DRB Application No.: 07DRB-70353 Project # 1006913  
Project Name: Univ. Hg Addition  
Agent: SUN-JEK Phone No.: 897-3366

**CITY OF ALBUQUERQUE  
PLANNING DEPARTMENT  
November 7, 2007  
DRB Comments**

**APPLICATION # 07-70333**

**RE: Lot 1-A, 1-B, 2, & 3, Block 40, University Heights/p&f**

PLAT OF  
**ONE TEN RICHMOND**

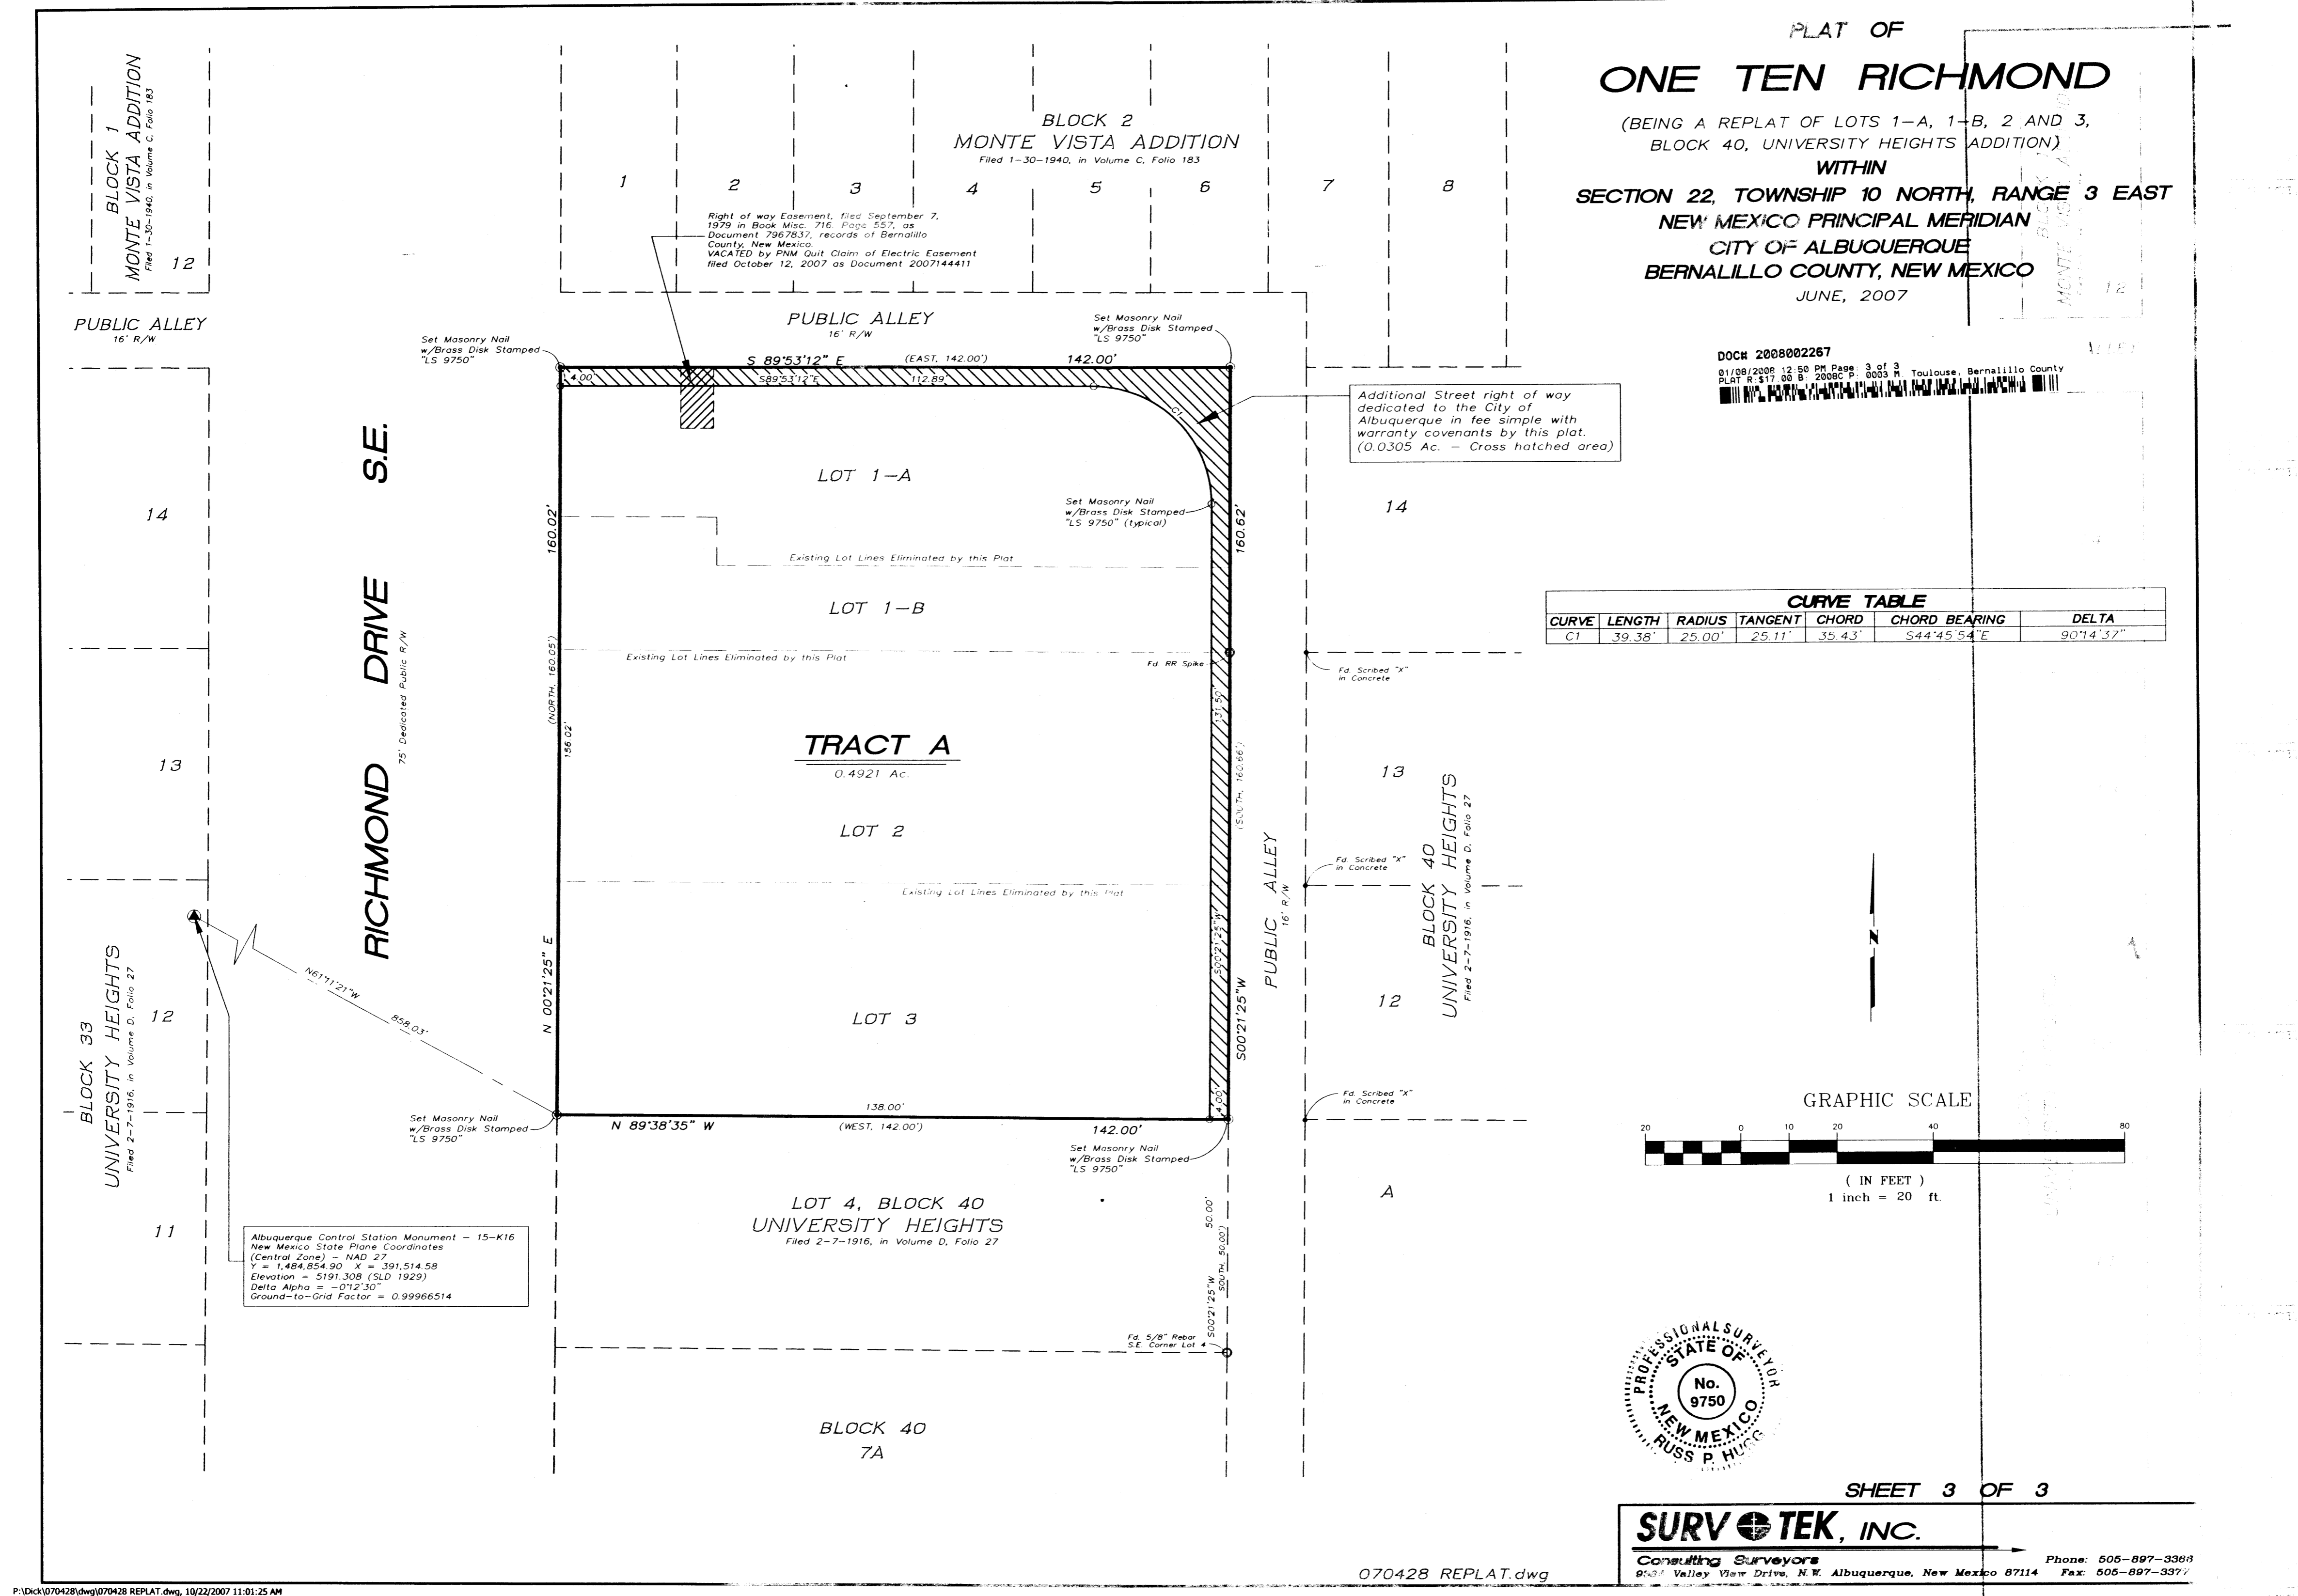
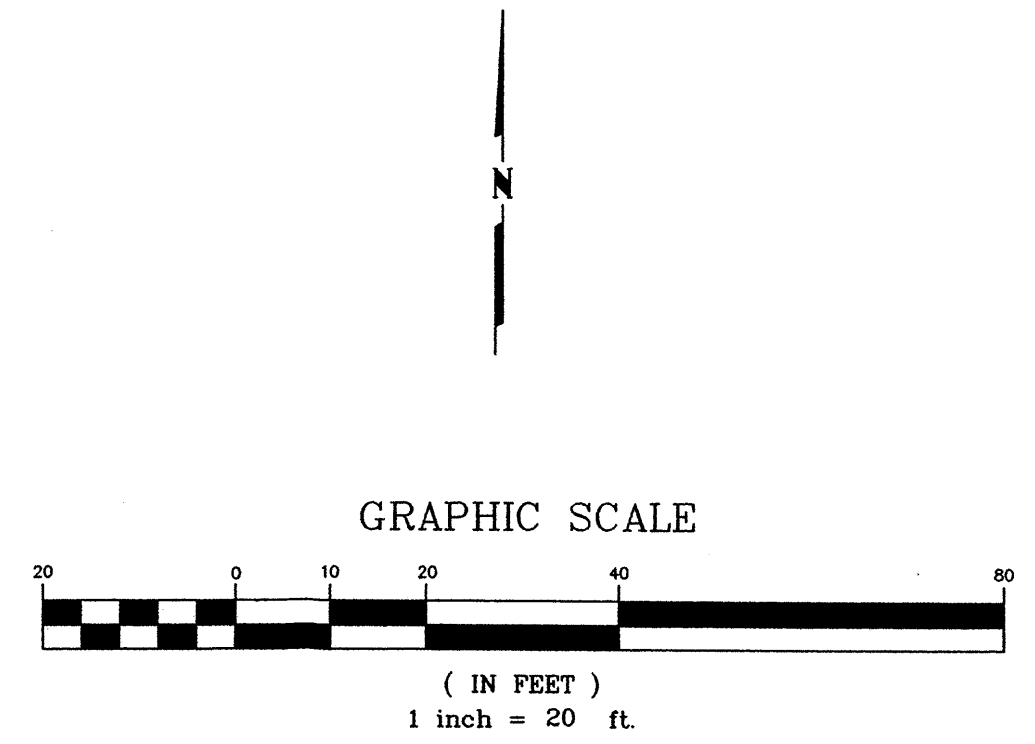
The zoning on the plat should be CCR-1.

The Please be advised that any plats approved by DRB must contain the following language per the City Subdivision Ordinance:

Section 14-14-4-7(B) "No property within the area of requested final action shall at any time be subject to a deed restriction, covenant, or building agreement prohibiting solar collectors from being installed on buildings or erected on the lots or parcels within the area of proposed plat. The foregoing requirement shall be a condition to approval of this plat or site development plan for subdivision."

Planning will take delegation for the Solar collector language, the AGIS dxf, and to record the plat.
